About the application

Application number: 2019/93605	
What is the application for?:	Erection of 2 detached dwellings
Address of the site or building:	April Court, Roberttown, Liversedge, WF15 7RB
Postcode:

SITE PLAN 1:250

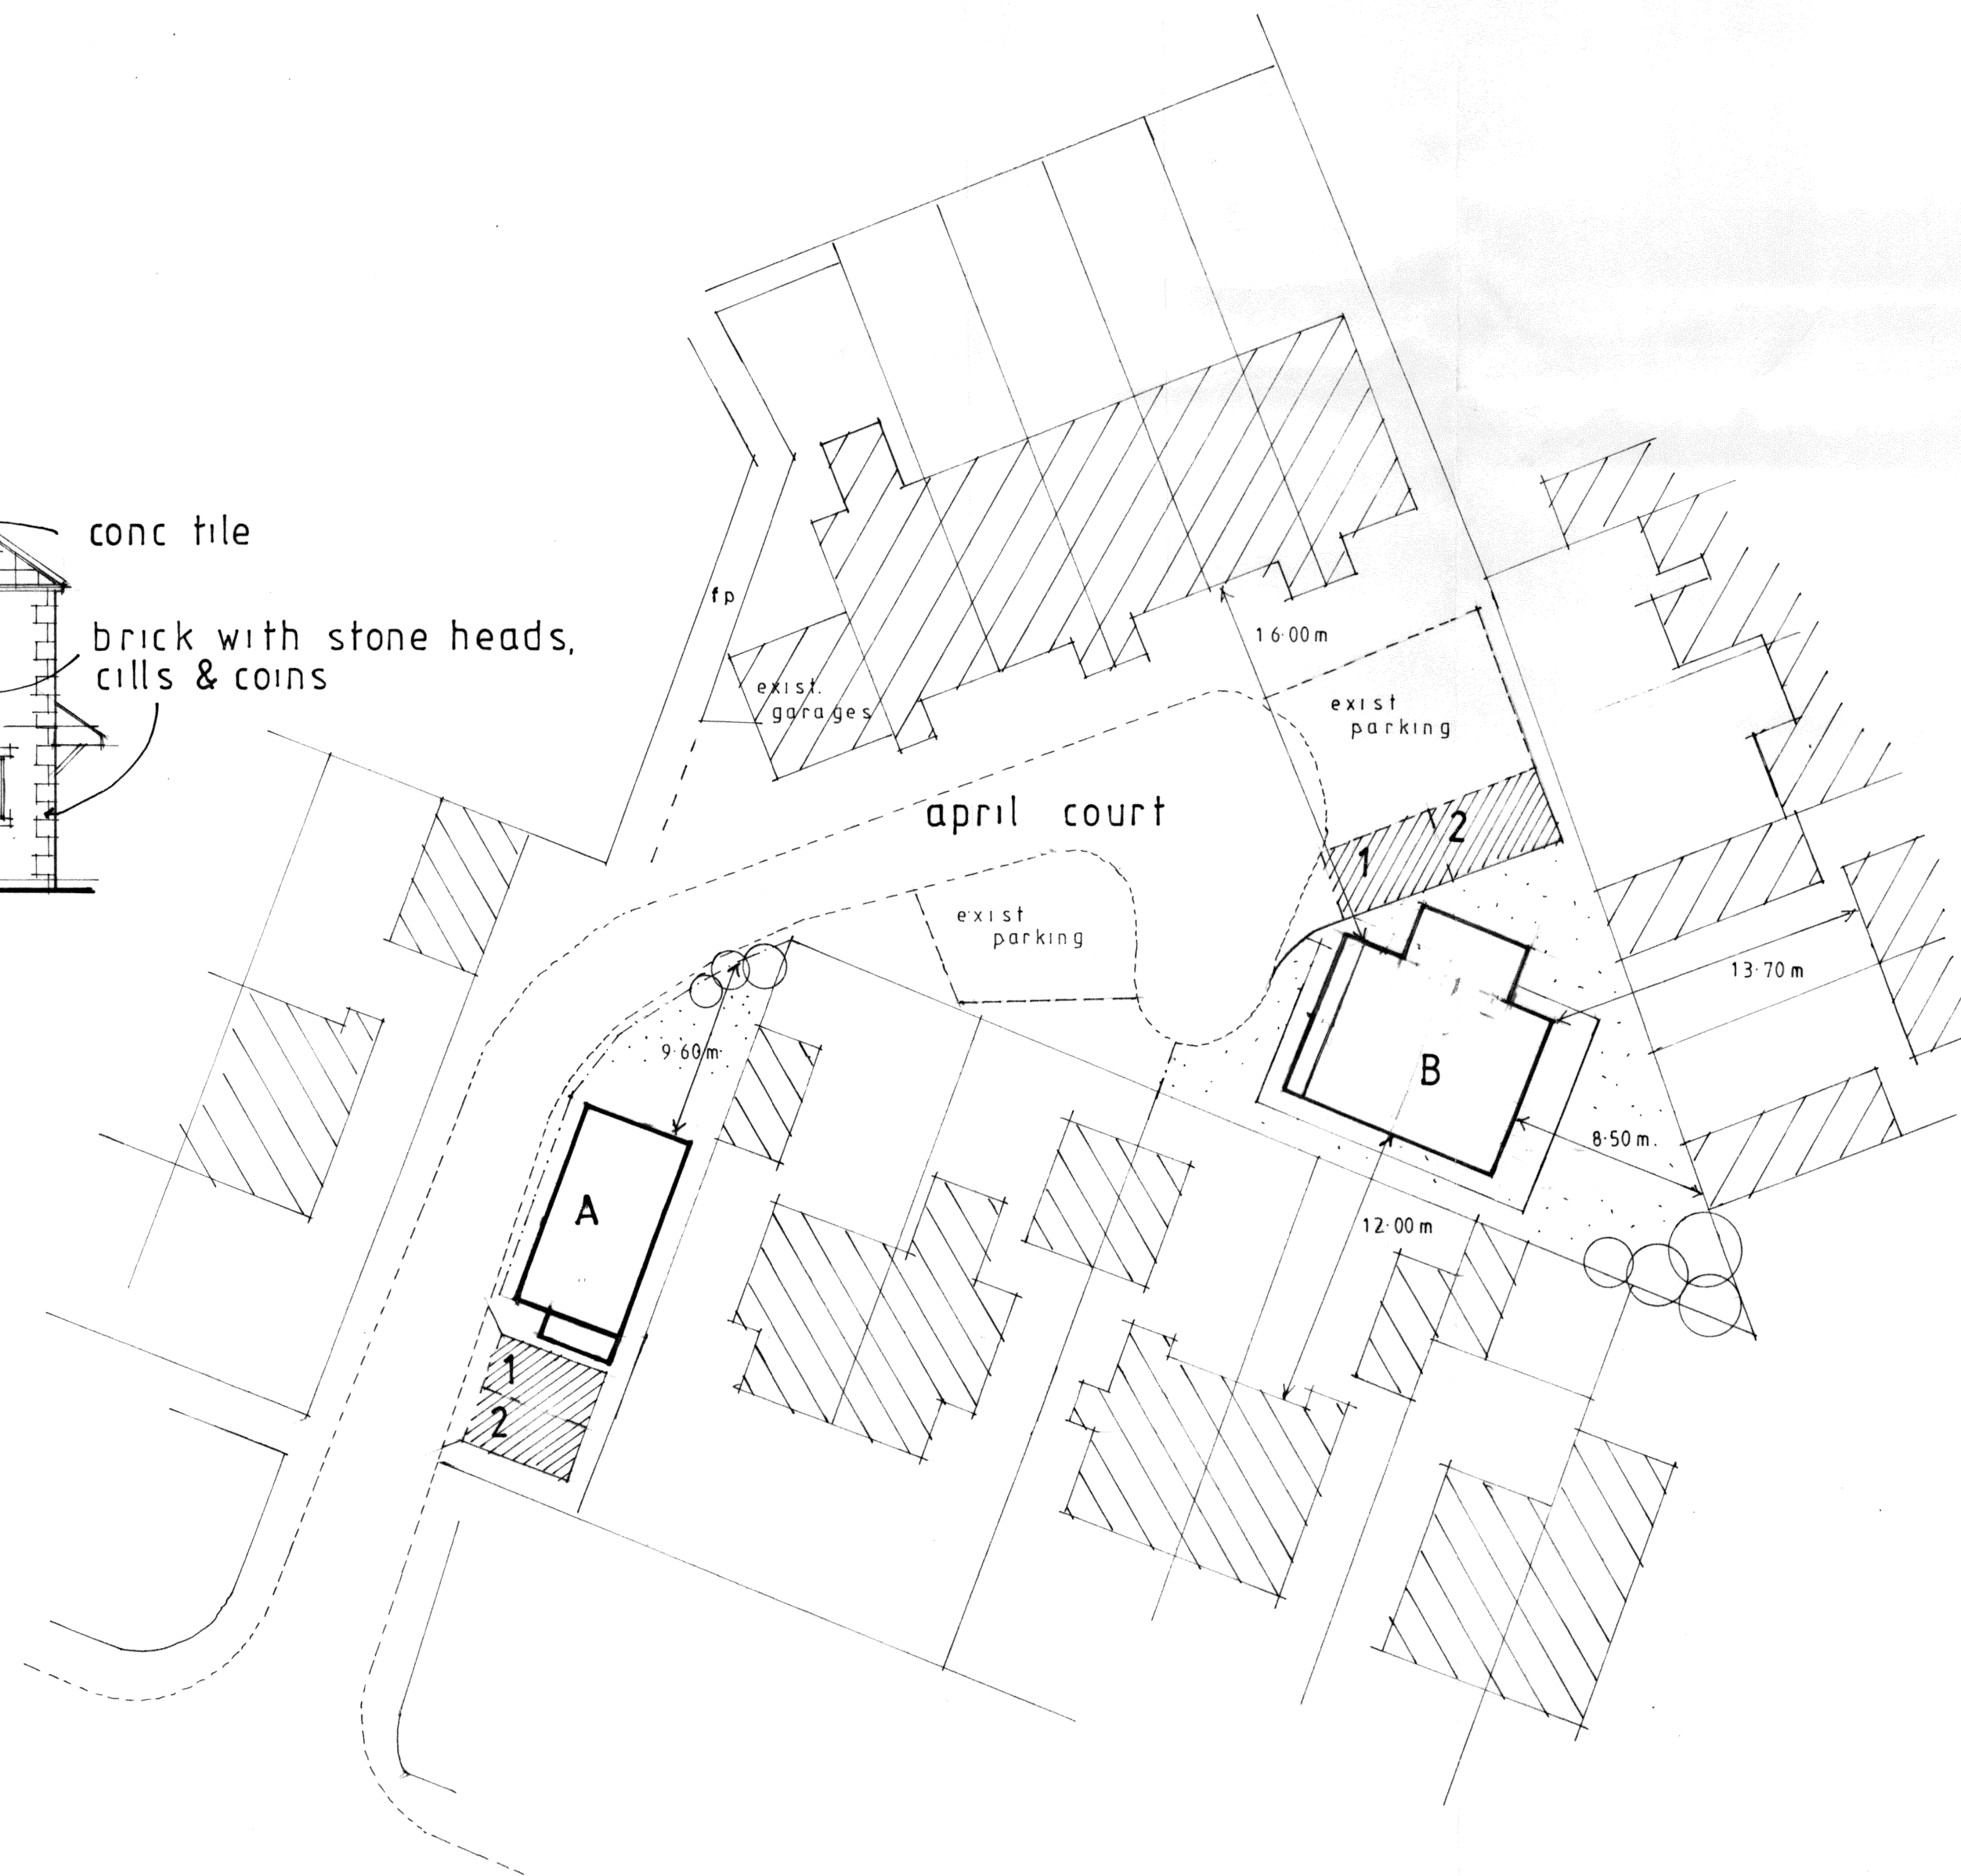
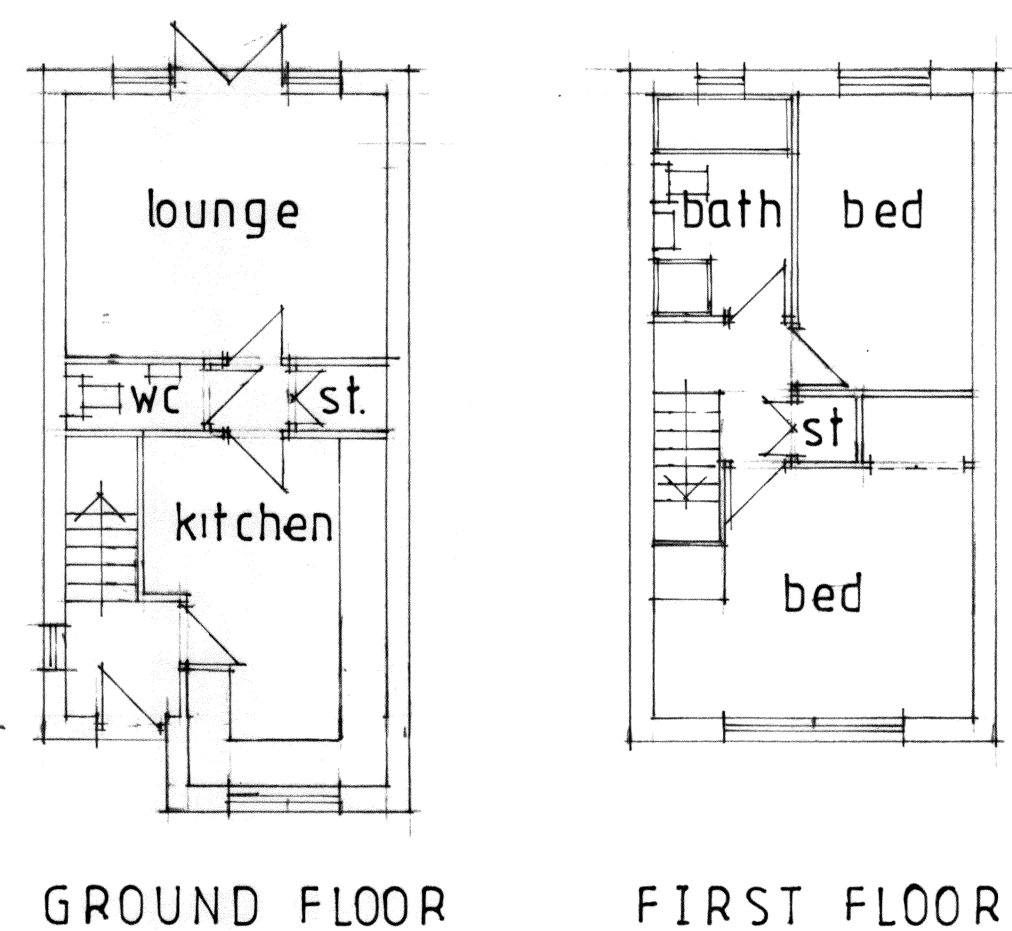
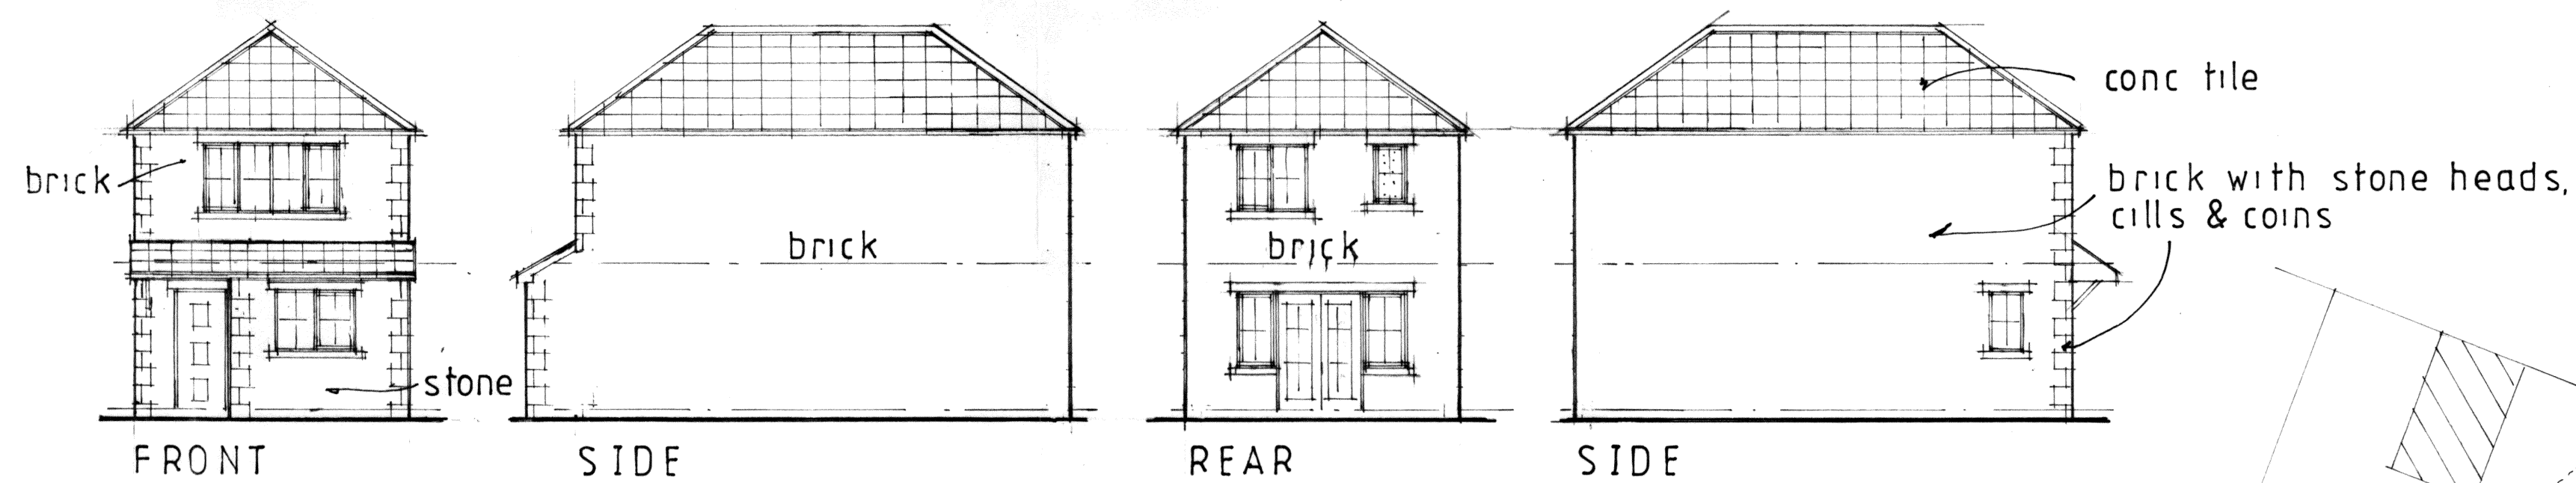
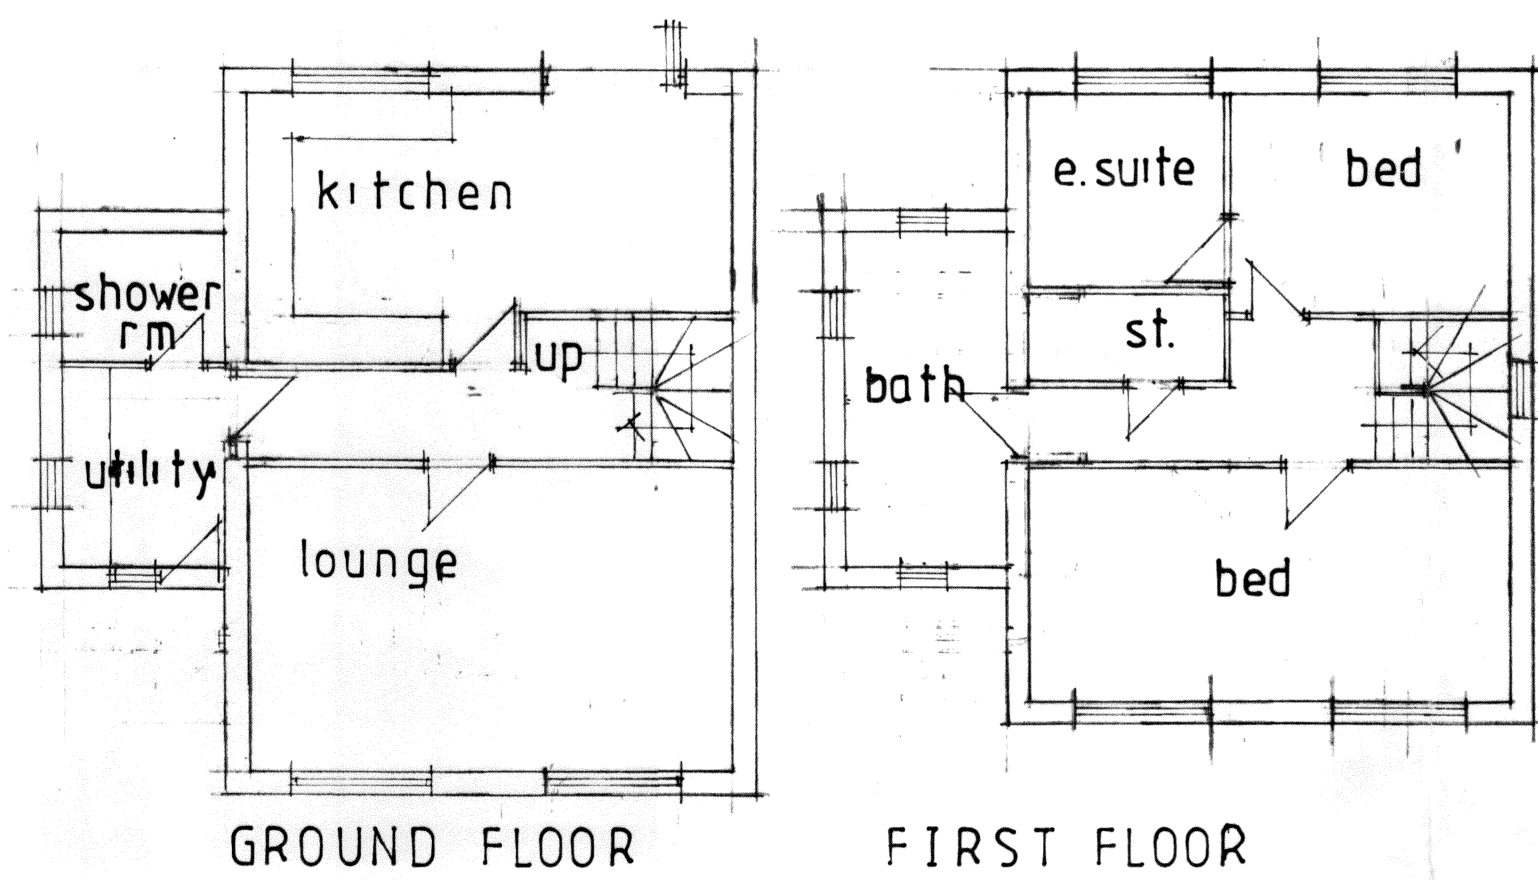
Type of comment: An objection
The main objections I have is the impingement on the existing surrounding properties. Second is the failure to provide sufficient space for an emergency vehicle to manoeuvre within the road area of April Court. Thirdly the plots mentioned within this application were originally subject to landscaping as per the plans approved for Dwellings number 1-5 on April Court. The landscaping was decided due to insufficient space caused by the required size of the turning circle. Yet the multiple more recent planning applications leads to the notion that the original plans including the size of the turning circle were not adhered to.
